From:
Sent: 01 January 2024 10:54
To: DCAdmin
Subject: Planning application 2023/93348

Concerning planning application 2023/93348.

Proposed Front Elevation

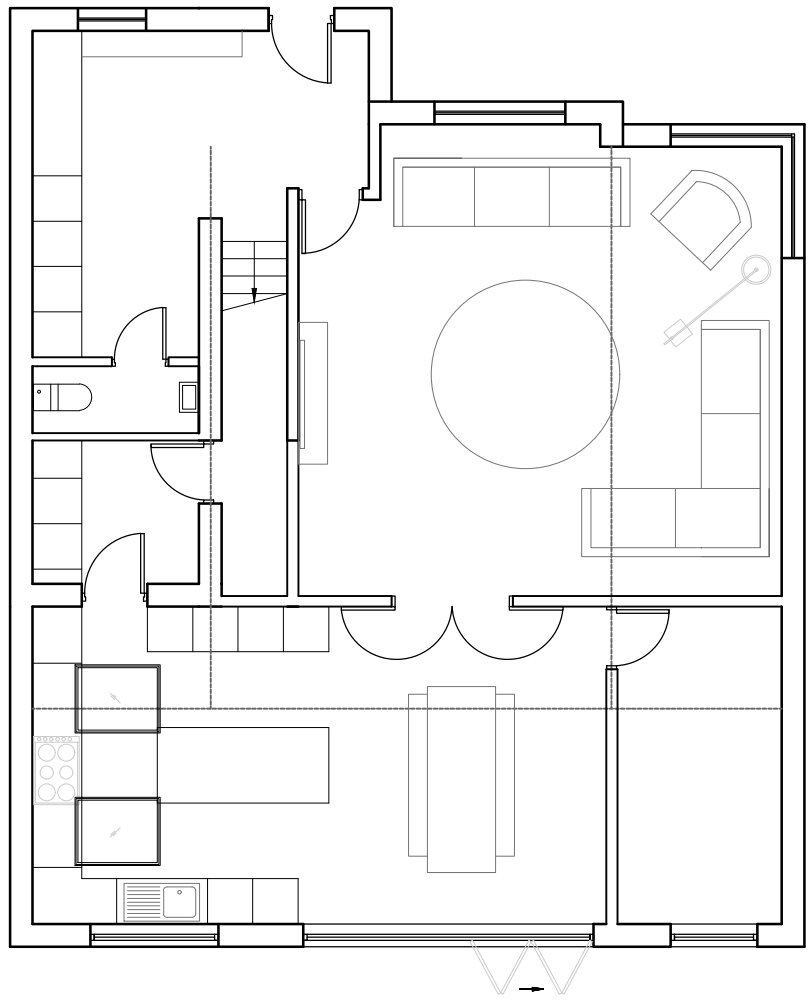
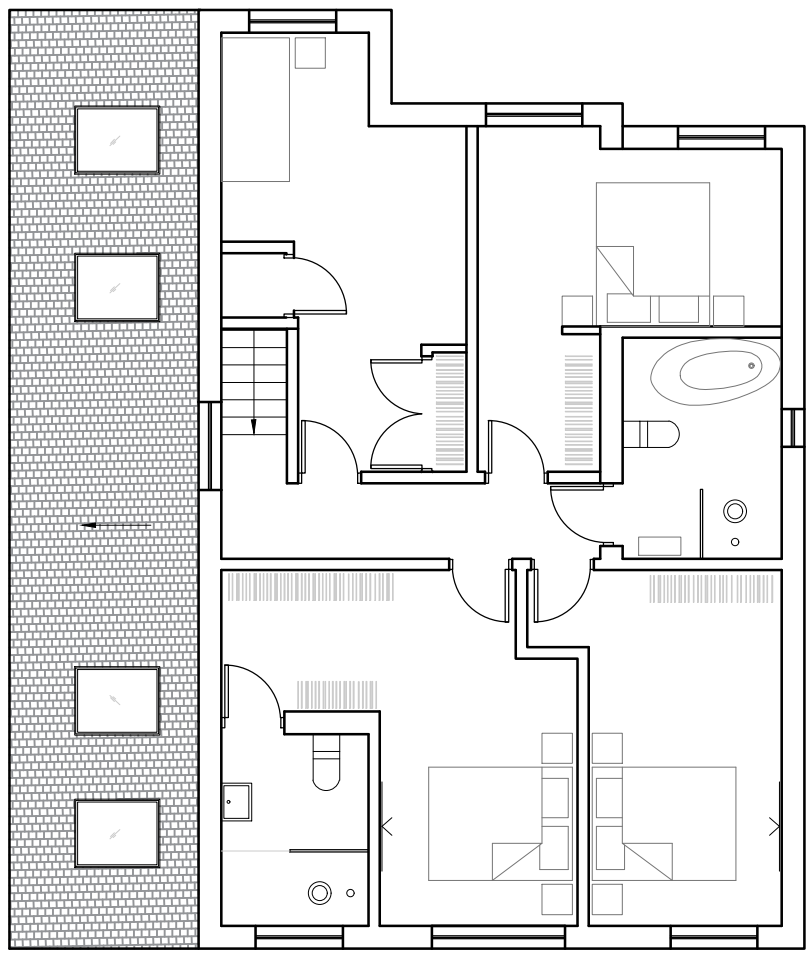
We have concerns regarding the building extensions proposed at 22 Goldcrest Court. This will be right up close to the boundary of our premises. This will give problems of access during the building and throughout the lifetime of the extensions. Fitting the roof will be a problem and any future maintenance on the roofs, gutters, windows and walls will not be possible without access to our garden and possible erection of scaffolding and ladders.

We are also concerned that during building there could be damage to our boundary fence and its foundations due to its proximity.

There will also be a small loss of sunlight to our house and garden due to the increased height of the gable over the front door.

We feel that this extension proposal is ill advised as there will be no external access to their garden. The garden space at the rear provides plenty of space for extensions.
